**KIRKLEES METROPOLITAN COUNCIL
INVESTMENT & REGENERATION SERVICE**

**DELEGATED DECISION FOR DISCHARGE OF CONDITION A.4 -
NOTIFICATION OF A PROPOSED ENLARGEMENT TO DWELLINGHOUSE**

Reference no.	2025/HH/92797/E
Site Address	Laneside, Scopsley Lane, Whitley, Dewsbury, WF12 0NG
Description	The proposal is for erection of single storey rear extension. The extension projects 4.36m beyond the rear wall of the original dwellinghouse. The maximum height of the extension is 3.35m, the height of the eaves of the extension is 2.86m
Recommending Officer	Joanna Rednall

Drawing Title
Proposed Elevations

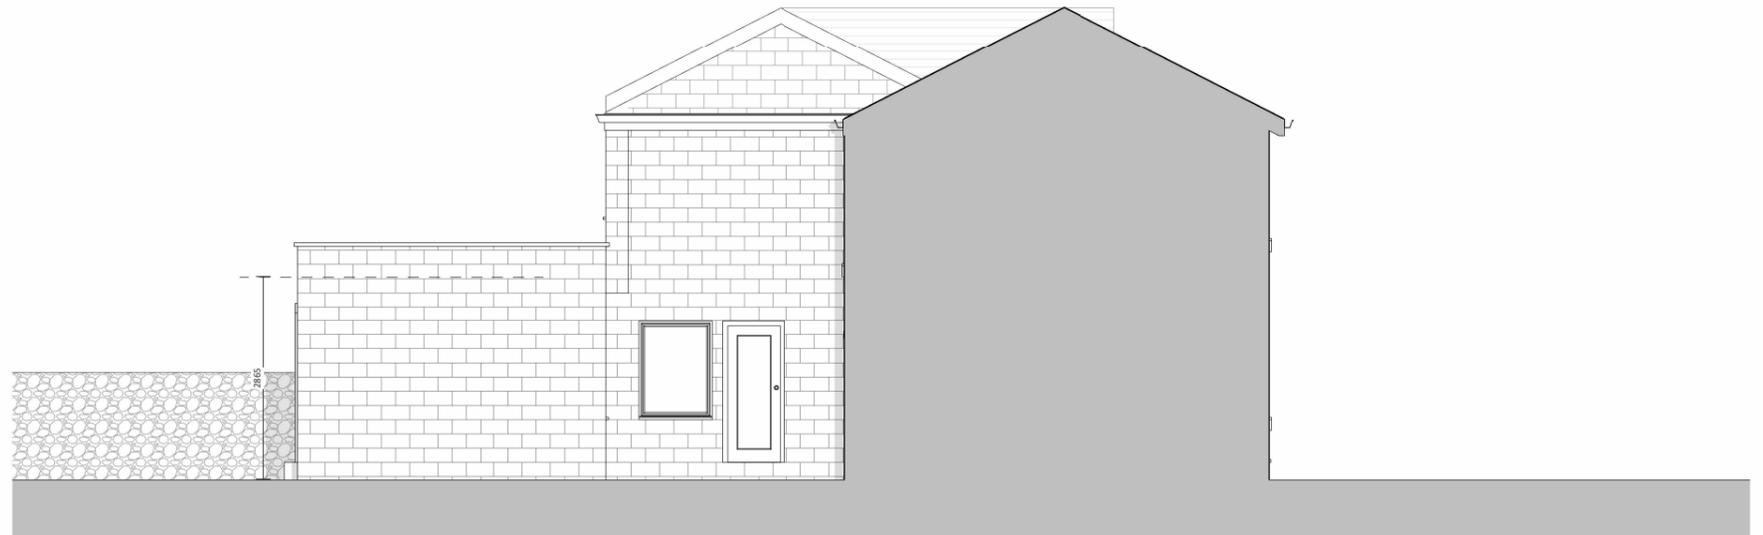
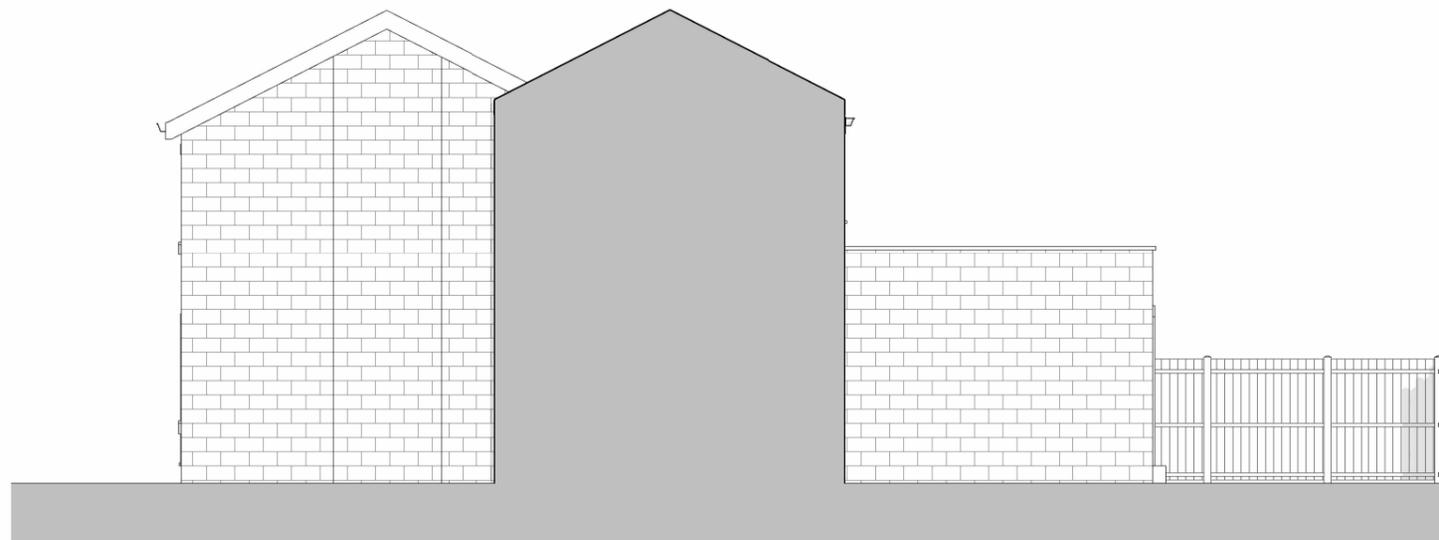
Sub- paragraph (ja) of Class A, Part 1, Schedule 2 of the Town and Country Planning (General Permitted Development)(England) Order 2015(as amended) provides that where proposed enlargements adjoin an existing enlargement to the original dwellinghouse then both the existing and proposed enlargement are to be considered as one enlargement for the purposes of assessing subparagraphs (e) to (j). In this instance, the combined two and single storey enlargements would have more than one storey and project 7.8 metres from the rear of the dwellinghouse and be within 2 metres of the boundary with an eaves height in excess of 3 metres contrary to subparagraphs (h) & (i).

The proposed enlargement does not benefit from a general planning permission under Article 3(1) and Class A, Part 1, Schedule 2 of the Town and Country Planning (General Permitted Development)(England) Order 2015(as amended) as the proposed enlargement adjoins an existing two storey enlargement to the original dwellinghouse where the combined two and single storey enlargements would have more than one storey and project more than 3 metres from the rear of the original dwellinghouse and be within 2 metres of the boundary with an eaves height in excess of 3 metres contrary to sub-paragraphs (h), (i) and (ja) of Class A.

Drawing Title  
Proposed Floor Plans

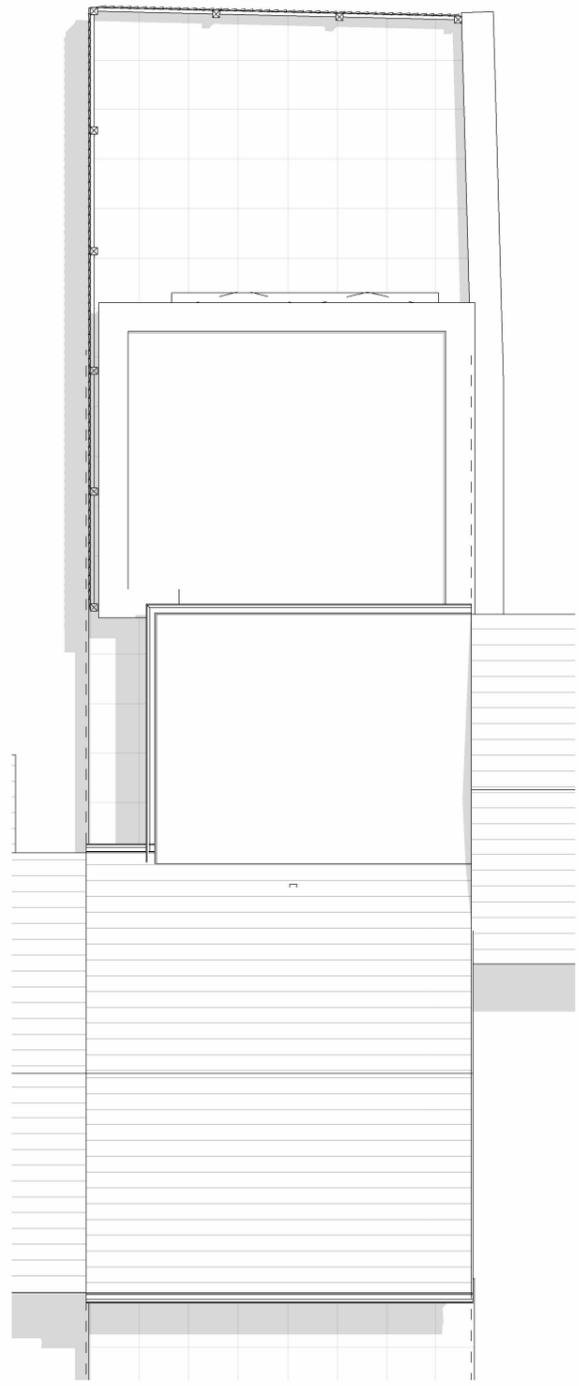
Is the site within a Conservation Area, Article 4 or SSI area?	No
Is any part of the proposal clearly outside the curtilage of the dwellinghouse?	No
If the house is detached and from the information submitted, does the extension extend more than 8 metres from the rear of the original dwellinghouse?	N/A
If the house is not detached and from the information submitted, does the extension extend more than 6 metres from the rear of the original dwellinghouse?	The application form states that the proposed enlargement would project 4.36 metres from the rear wall of the original dwellinghouse. However, when taking into account the existing two-storey rear extension, the total projection of the proposal would be approximately 7.8 metres from the

original rear wall of the dwelling.
Does the proposal exceed 4 metres in height?	No
Have permitted development rights been removed from the property?	No

The property's planning history and aerial imagery shows that a two-storey extension has been erected to the rear elevation. This extension is present on aerial imagery dated 2000 held by the Council and is not present on historic imagery dated 1955 and 1922, indicating it is not an original rearward projection. The proposed single storey rear extension projecting further from the existing enlargement would therefore adjoin a two-storey enlargement.
